Recommendation Report for Planning Permission for Works or Extension to a Dwelling

REF NO: Y/21/26/HH

LOCATION: 37 Briar Close
Yapton
BN18 0ES

PROPOSAL: Wrap around flat roof extension and front porch extension.

Proposed Floor Plan

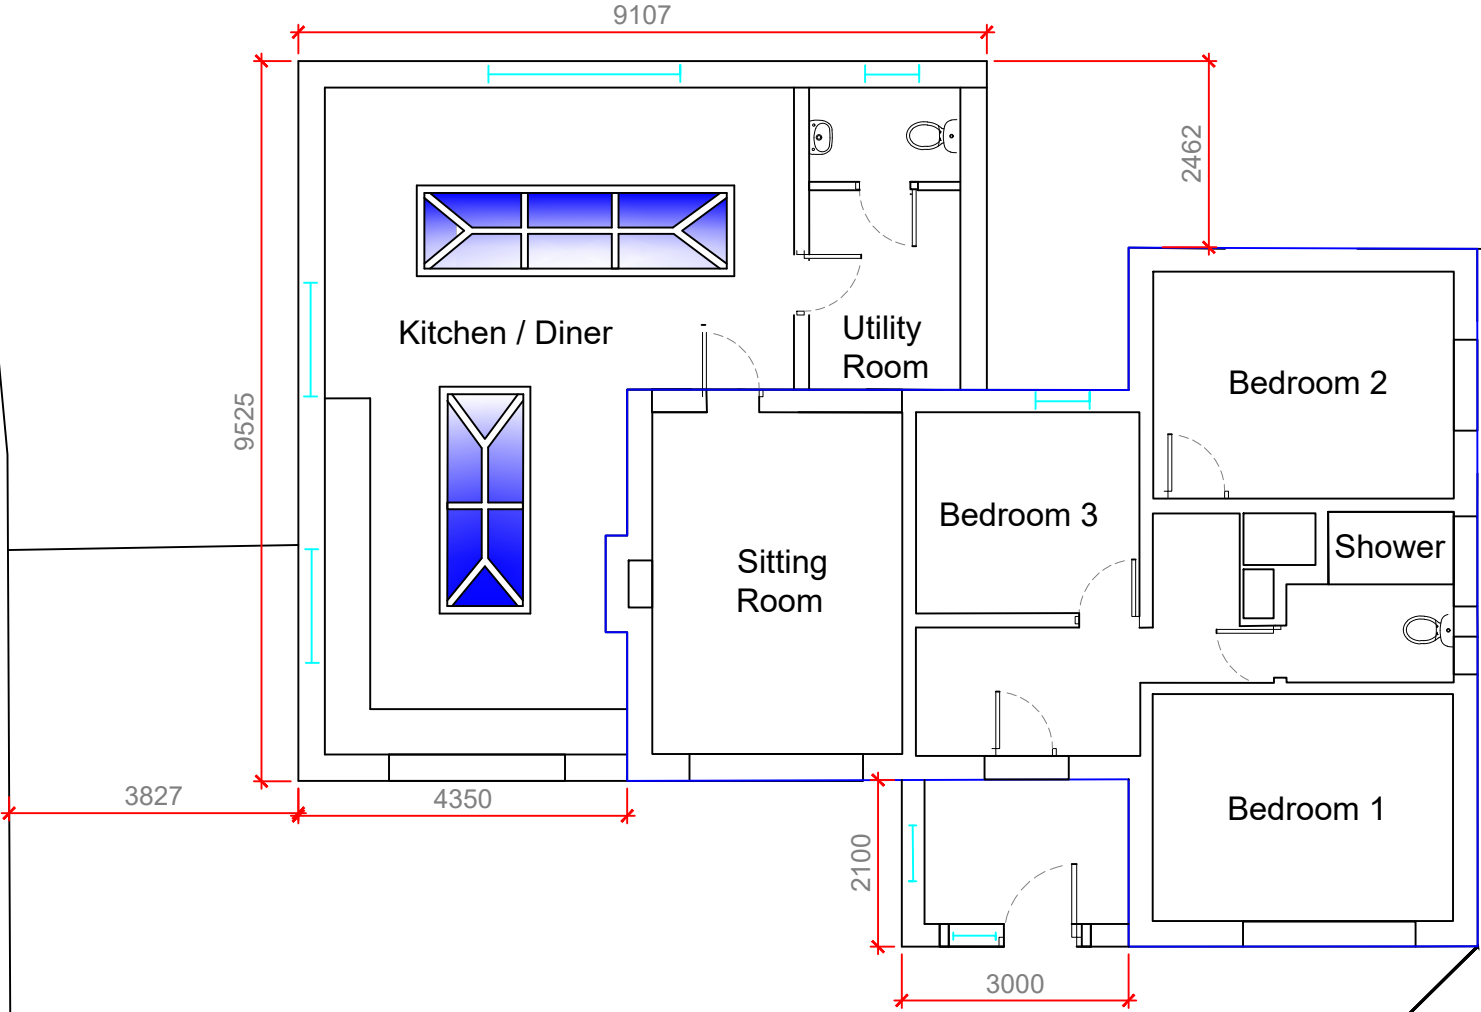
The L-shaped extension would wrap around the south-east side and rear of the dwelling. It would measure 9.1m across the rear, 9.6m in depth and 4.3m across the front. The extension would have a flat roof with a 2.8m eaves height and two lantern rooflights, giving a maximum height of 3.3m. The rooflights would be proportionate to the extension and would not cause visual harm. The ADG advises that side extensions should respond to the design of the host building, including its roof pitch, and incorporate complementary, well-integrated materials and elevational detailing. The extension would be finished in brickwork to match the host dwelling. Although it would alter the dwelling's appearance, Briar Close has a varied street scene characterised by a range of extensions and alterations. In particular, the adjoining property at No. 35 has a flat-roofed side extension. The proposal would therefore not appear out of keeping with the street scene.

The application site adjoins neighbouring properties to the north, east and west. The wrap-around extension would be set in 10.2m from the rear boundary, 10.5m from the western boundary and 3.2m from the eastern boundary. Given these separation distances and the extension's single-storey scale, it would not have an overbearing effect or cause harmful overshadowing. Its windows and doors would be at ground-floor level and would face the host dwelling's rear and side amenity areas, as well as the site frontage. They would therefore not result in harmful overlooking.
